**KIRKLEES METROPOLITAN COUNCIL
INVESTMENT & REGENERATION SERVICE**

DELEGATED DECISION TO DETERMINE PLANNING APPLICATIONS

Reference No:	2022/62/92072/W
Site Address:	3, Arrunden Court, Holmfirth, HD9 2AP
Description:	Erection of single storey rear extension
Recommending Officer:	Laura Yeadon

DECISION – CONDITIONAL FULL PERMISSION

south elevation
(if extension not built @ nr.4)

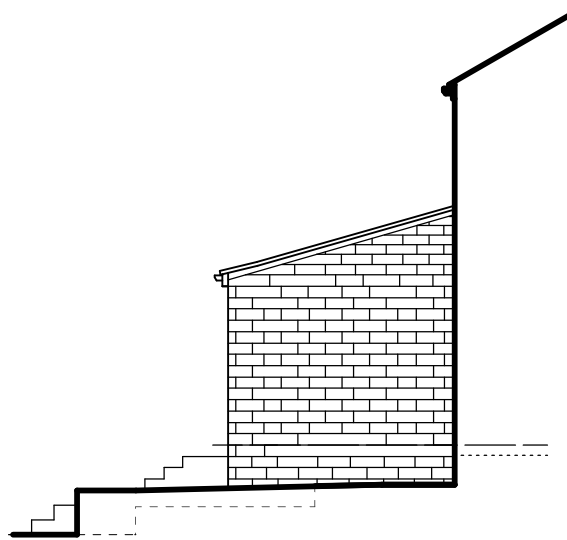
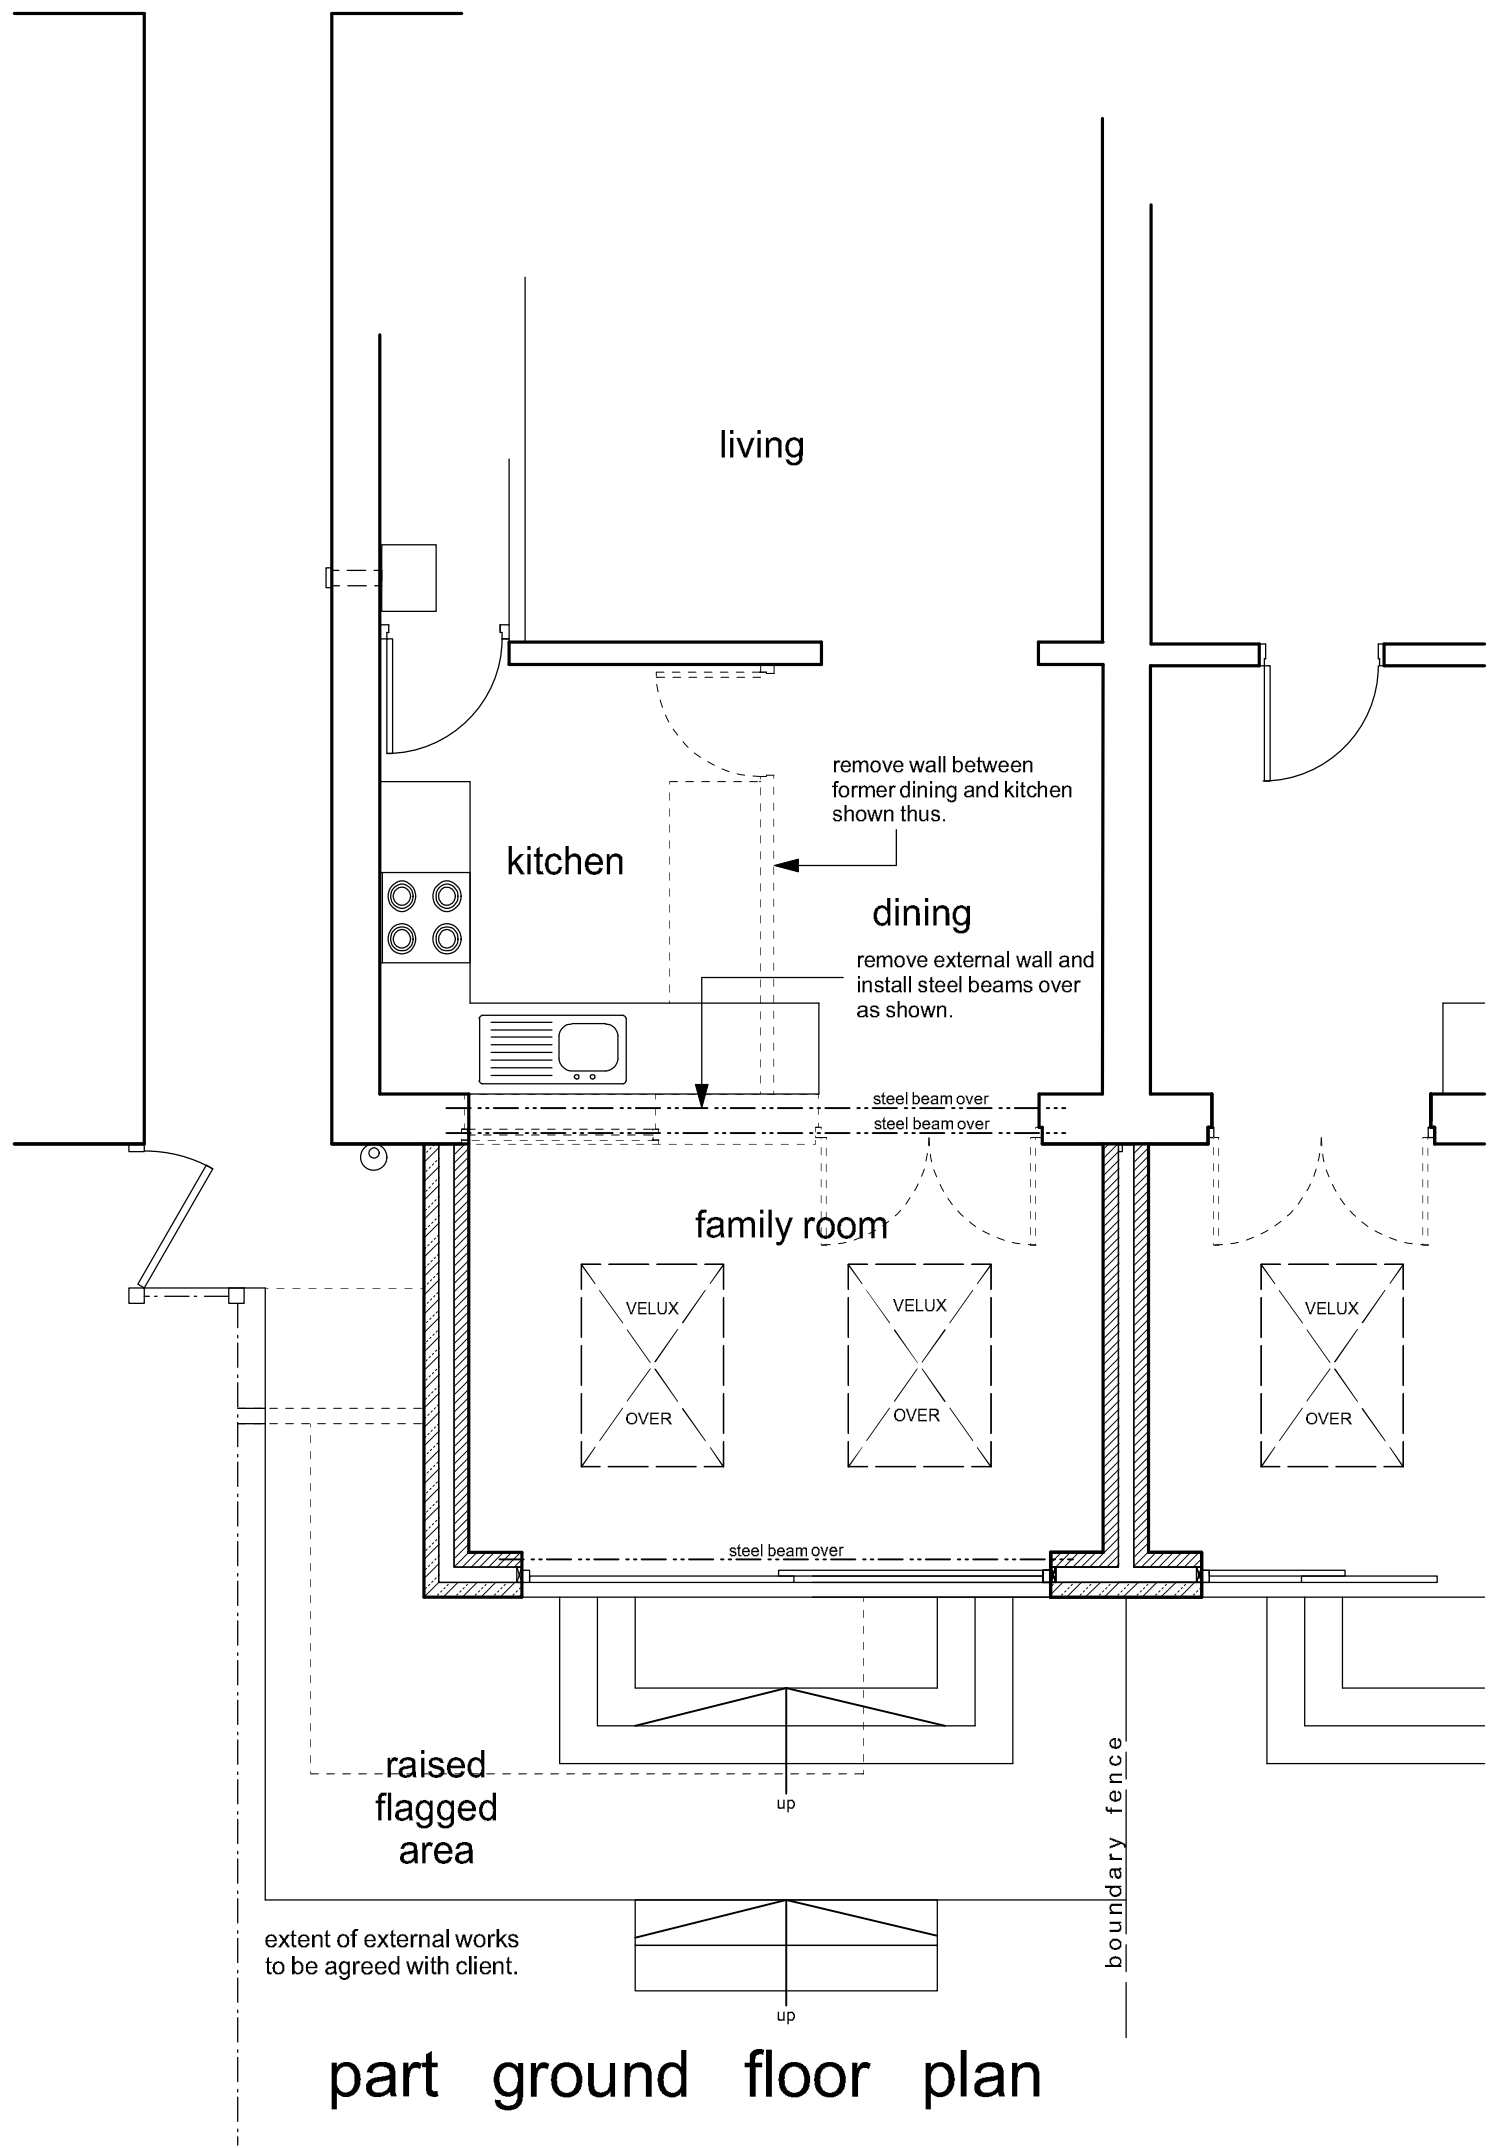
The Agent was contacted and asked to submit updated plans for both this and the application on the attached neighbouring demonstrating a proposed side elevation for each property in the event that development was not commenced on one of the properties. This was to ensure a satisfactory development upon completion.
